From: Amanda Scholes on behalf of Planning.Responses
Sent: 21 December 2016 08:38
To: Planning Scanning
Subject: FW: Planning Consultation on: BN/52/16/RES

Comment from Greenspace

The landscape scheme proposed under this reserved matters application contained in planting plan drawings P1 of 3 2600-00-09 Rev P2, P2 of 3 2600-PP-11 Rev P2, P3 of 3 2600-PP-11 Rev P2, detailed planting plans 2600-PP-07 & 08 in general provides a good species selection of mixed native evergreen and deciduous trees, herbaceous, shrubs and hedging plants which if given the correct protection and aftercare would create a suitable scheme. The details show trees and shrubs detailed at an appropriate size which will give instant impact, screening and softening to the development. The planting detail is shown in plan form detailing species mix, planting density and size at time of planting.

NOTIFICATION FROM ARUN DISTRICT COUNCIL
The Town & Country Planning Act 1990 (as amended)
Town & country Planning (Development Management Procedure)
(England) Order 2015 - Article 6
Approval of Reserved Matters Following Outline Approval
APPLICATION BN/52/16/RES
NO:

A registered practice of the Landscape Institute	
Client: Redrow Homes Southern Counties	Scale: 1:250@A1
Project: Pollards Nursery, Barnham Phase 2	By/Chk: LM/BB
Drawing Title: Planting Plan 1 of 3	Date: 28/09/16
Drawing Number: 2600-PP-09	Revision: P2

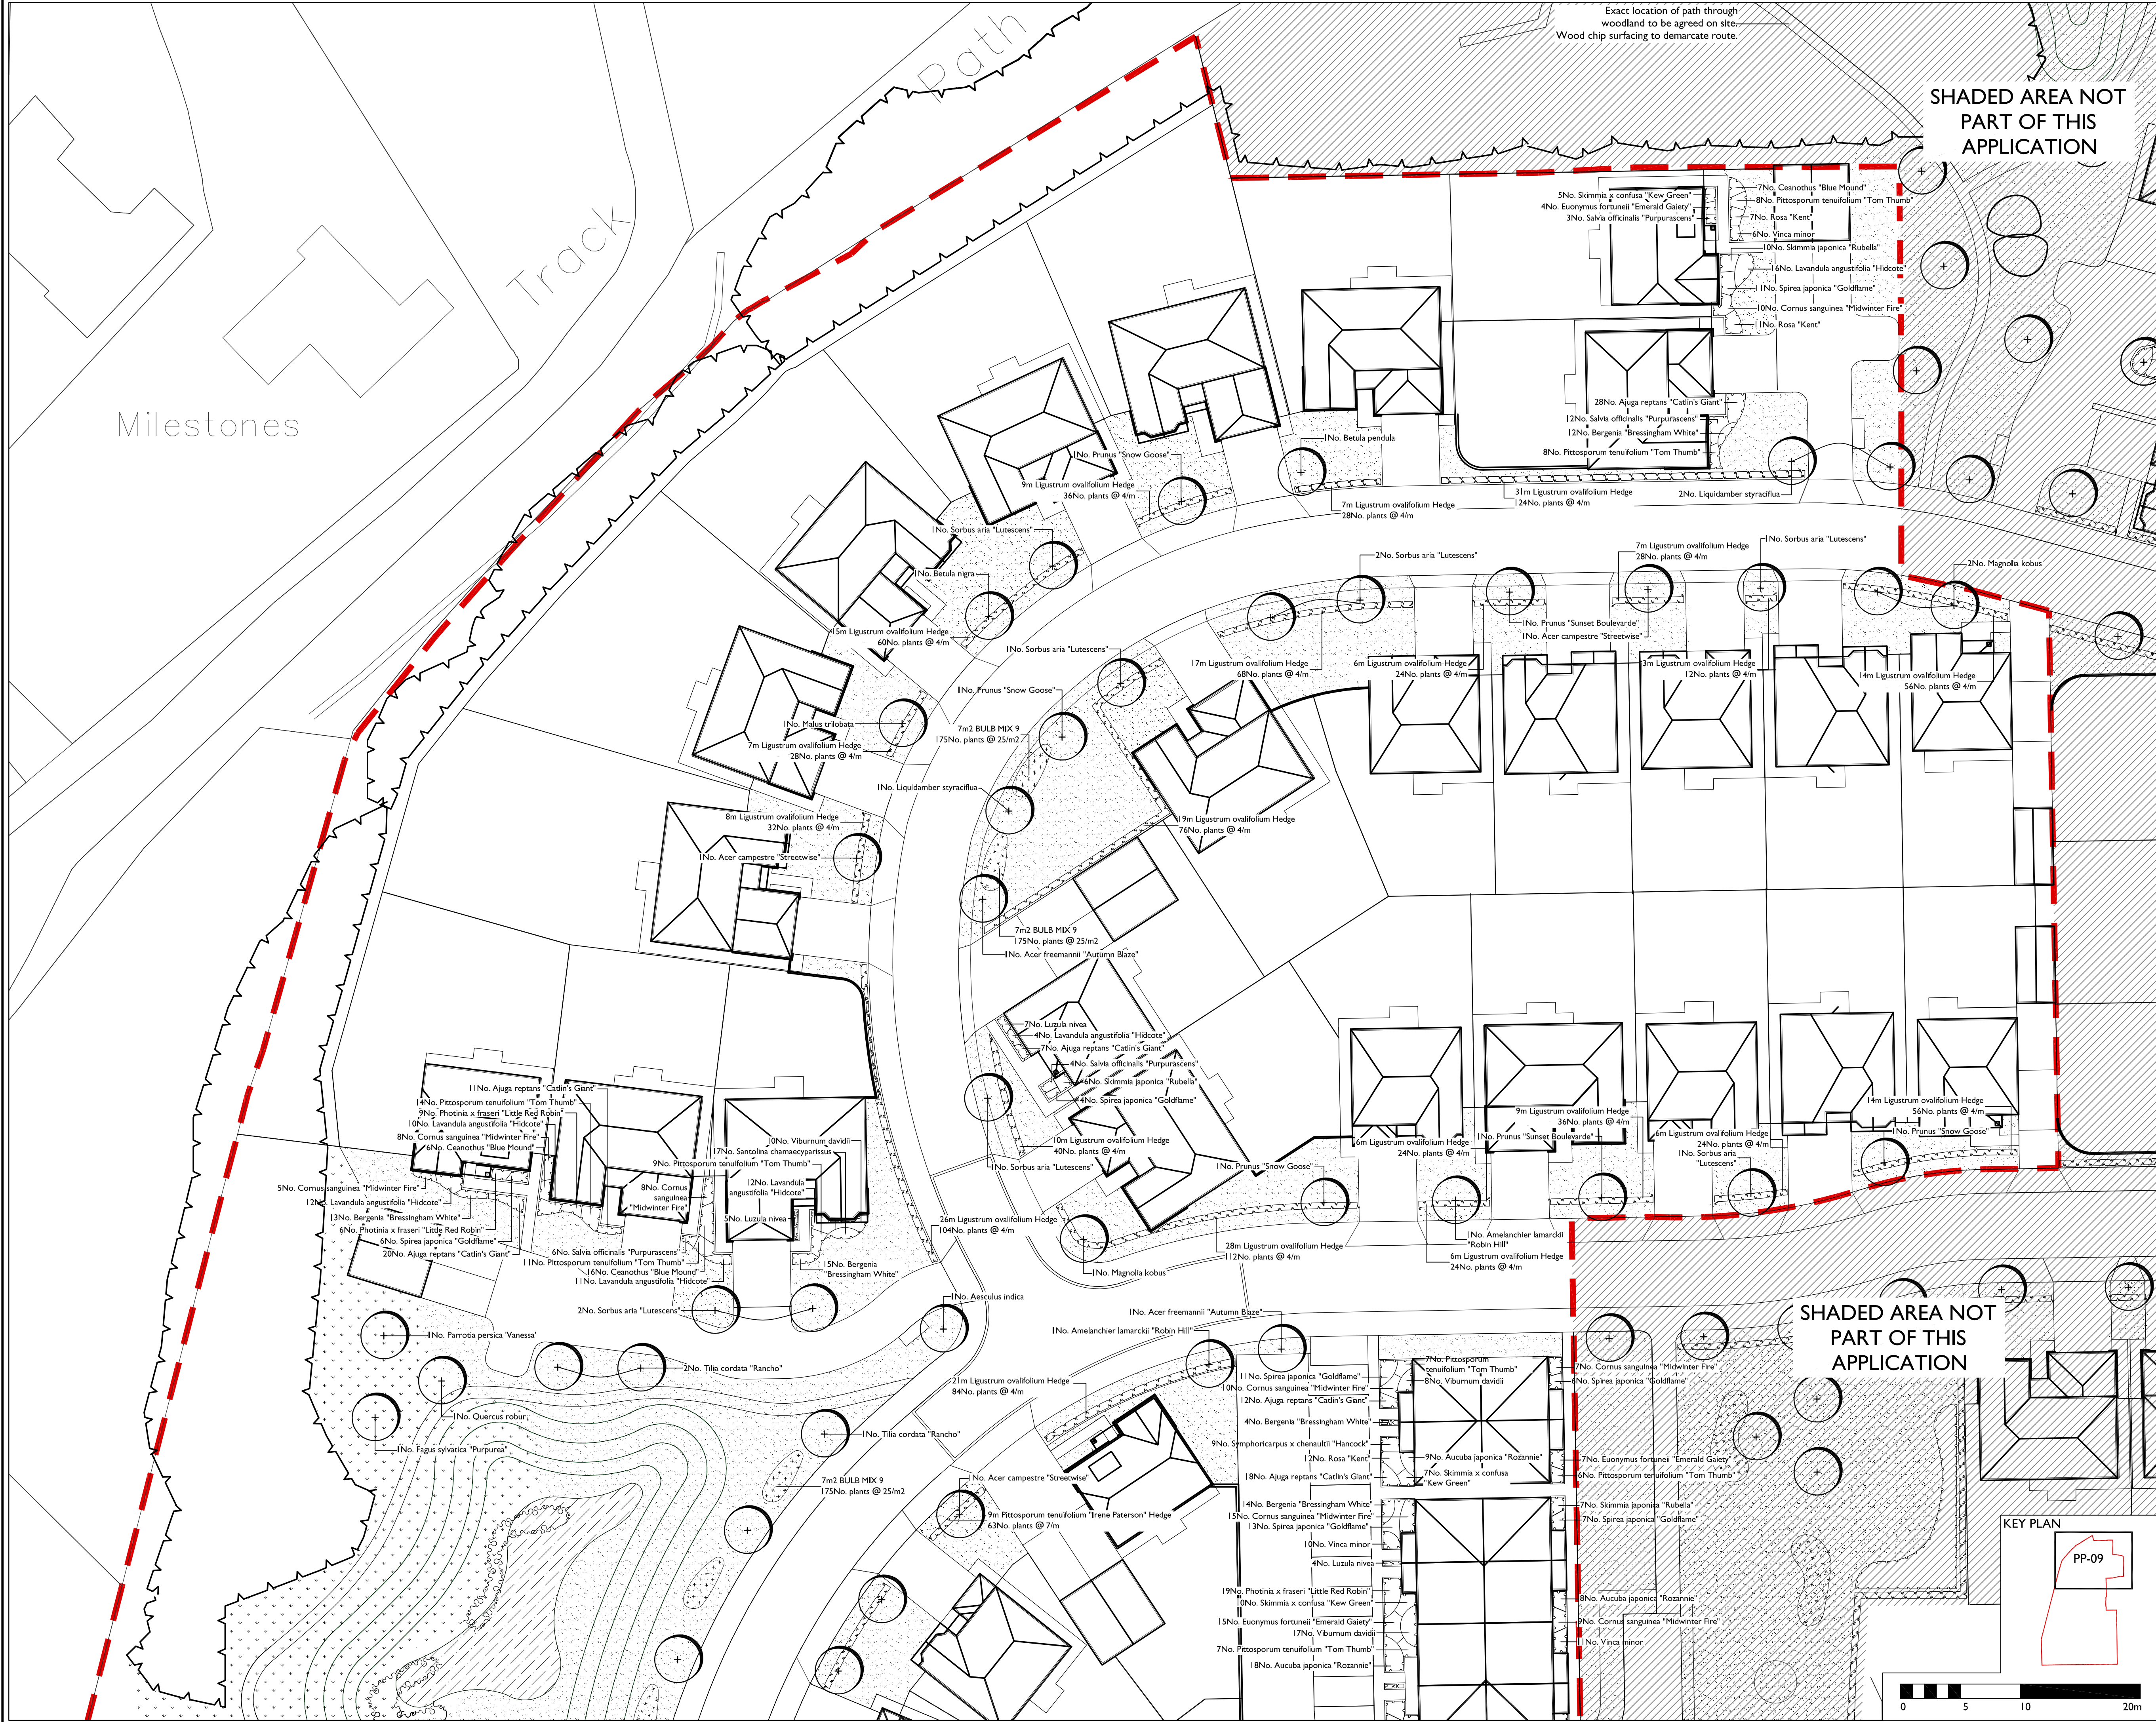
The inclusion of SUDS within the POS whilst providing some biodiversity benefit may limit the useable POS area in general. Information on the cross sections of the ponds to identify the water level and space around the ponds to be ascertained also to identify any potential impact on adjacent trees. The trees particularly to the western boundary of the site are particularly significant and in order to preserve these as a permanent feature it is welcomed to see these within the POS areas rather than private gardens. Protection of these during any construction works within the site must be adhered to in line with the submitted and approved tree protection plans.

Local Equipped Area for Play (LEAP)
Housing Developers Pack - Example Design

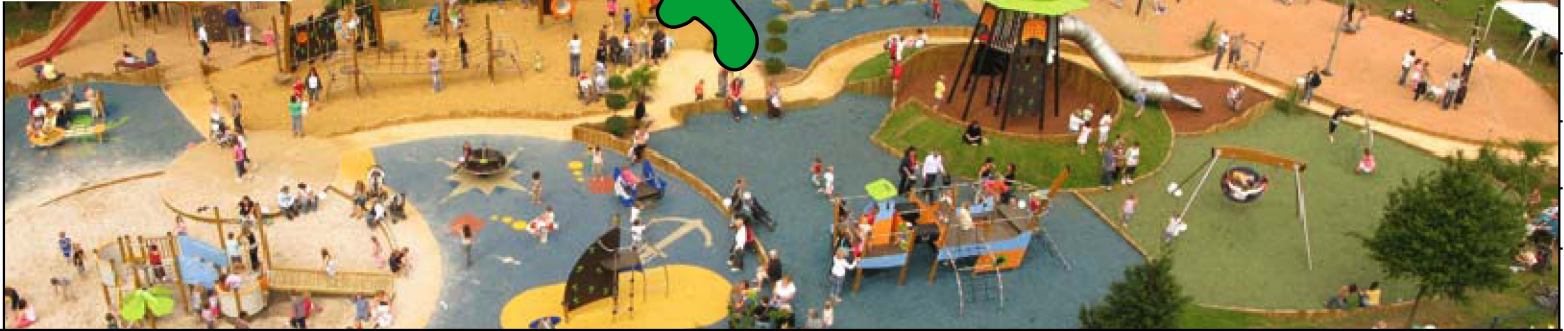
The LEAP area shown differs in the detail provided within the 3D visualisation Play space by Proludic drawing from that indicated in the masterplan drawings as approved. The space detailed appears to have been reduced in size with the equipment packed within a tight fenced play space. The LEAP example drawing provided shows 5 pieces of play equipment within a fenced 400m² but with comment that 'Enhanced LEAP added extras are indicative only' Clarification should be given as to what is being provided as it would appear that the indicated balancing trail (and surfacing) and bundling are not being provided? Does this differ from the outline approval?
